Hills District Kennel & Training Club Inc.

Submission: EIS 1

Application No (SSI-5100)

Figure 6 Norwest station – heavy vehicle routes

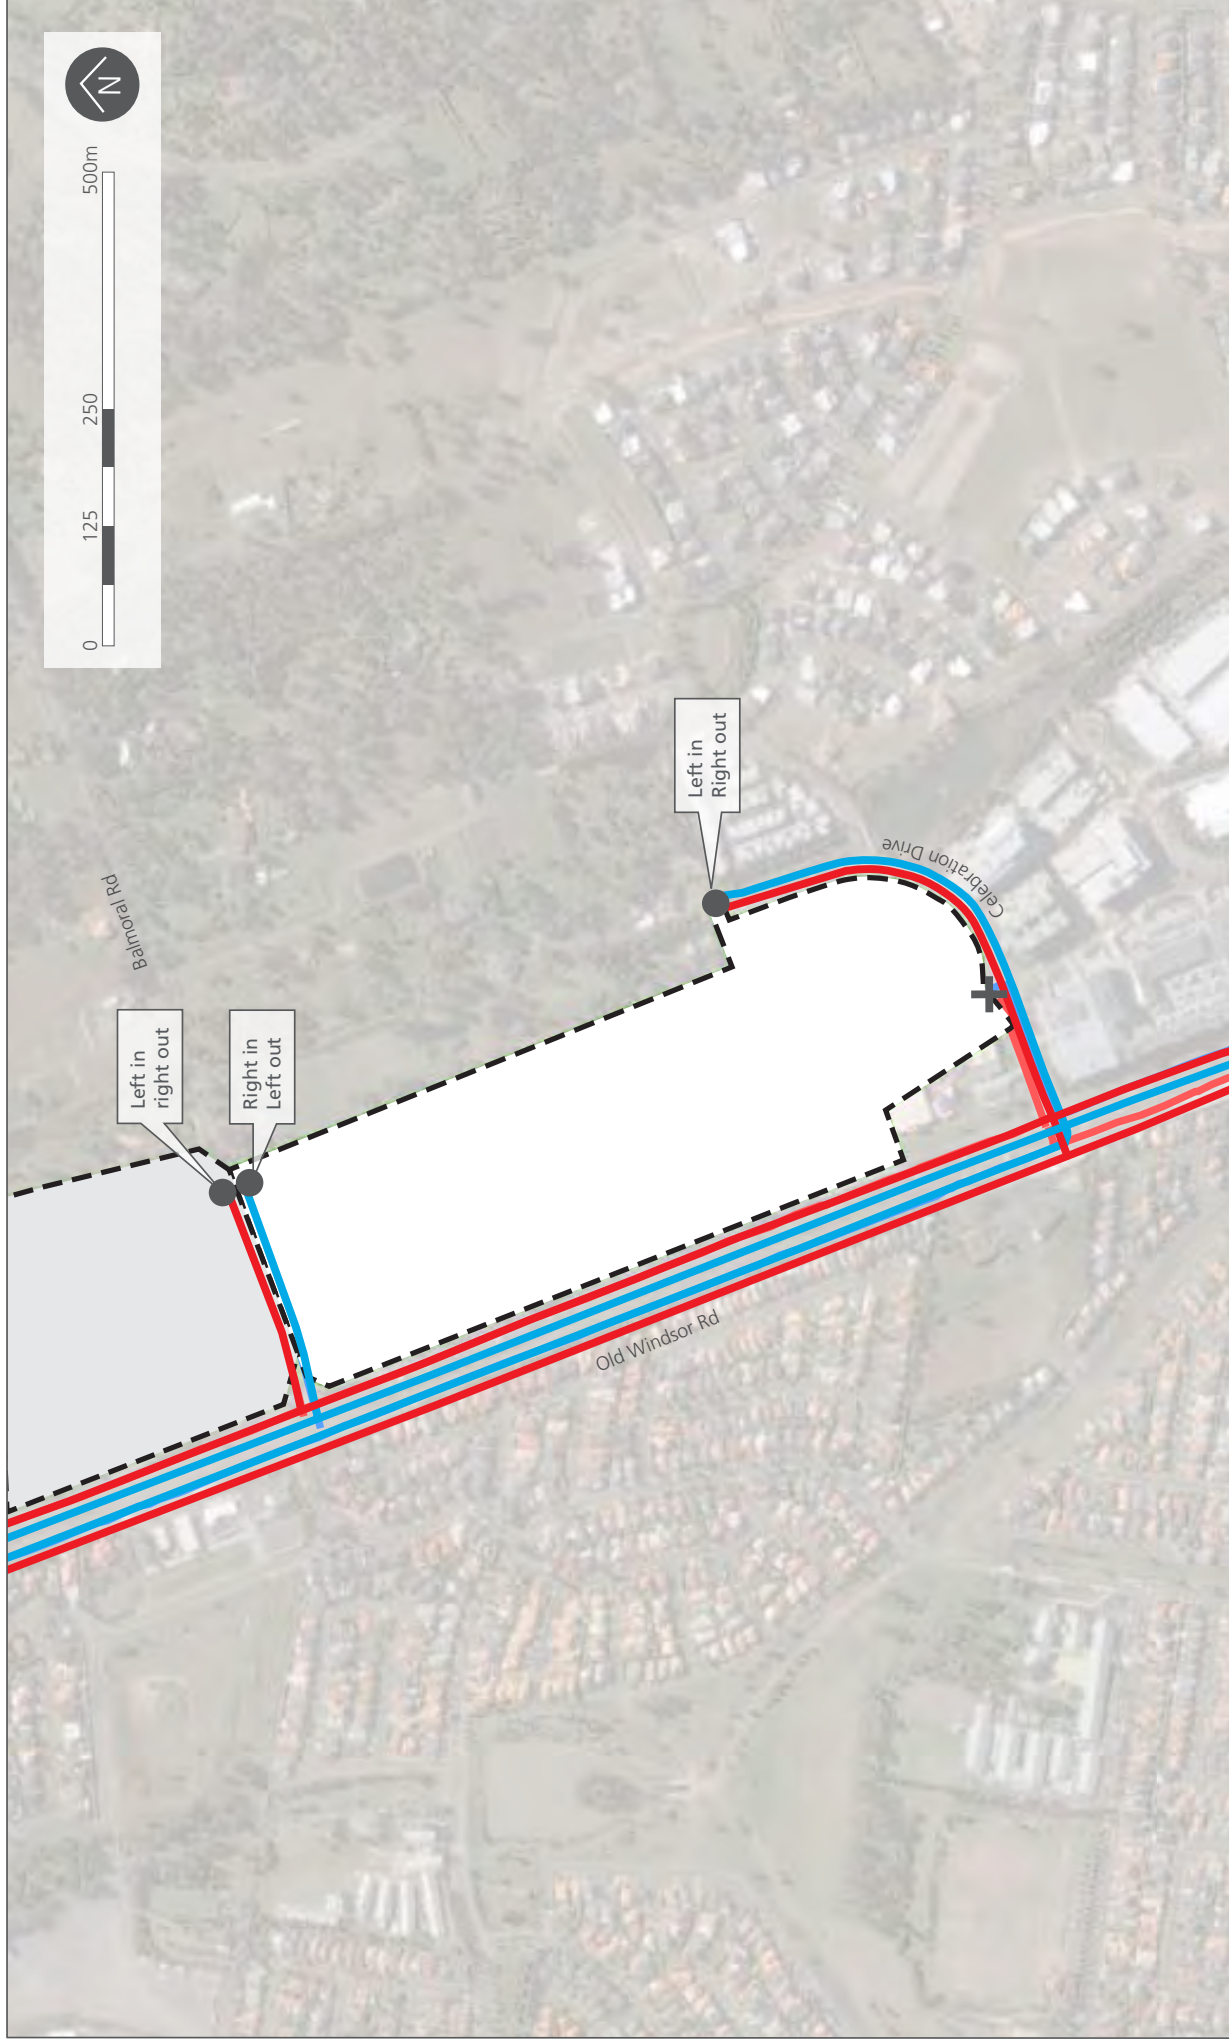
These concern the proposed haul road route adjacent to the Norwest Dog rings and undercover ring.

- Our major concern is that the safety of all our members and their dogs are not put at risk while training at the club. Enclosure of the proposed haul road is needed as we have dogs off lead, children running around and general pedestrian movement in this area of the showground.

- We believe noise barriers are necessary to reduce and control the noise levels created by the close proximity of the proposed road. Many dogs are noise sensitive and some humans have hearing problems.

- The dust from the construction and usage of the planned road by the large volume of heavy haulage vehicles will have a detrimental effect on both human and dogs that attend the grounds.

- Access to the dog rings from below the club house is needed for Ambulances, people with disabilities, mowing and maintenance of the dog rings.
- Access is needed to our storage area from underneath the building to bring equipment up for training, Obedience Trials and our Championship shows.

- Many members park their cars with dog trailers in this area to take advantage of the shade for their dogs during the day. The trees that are removed need to be replaced in another area.

- The parking that will be lost behind the club house needs to be replaced in another area with sufficient lighting for night classes.
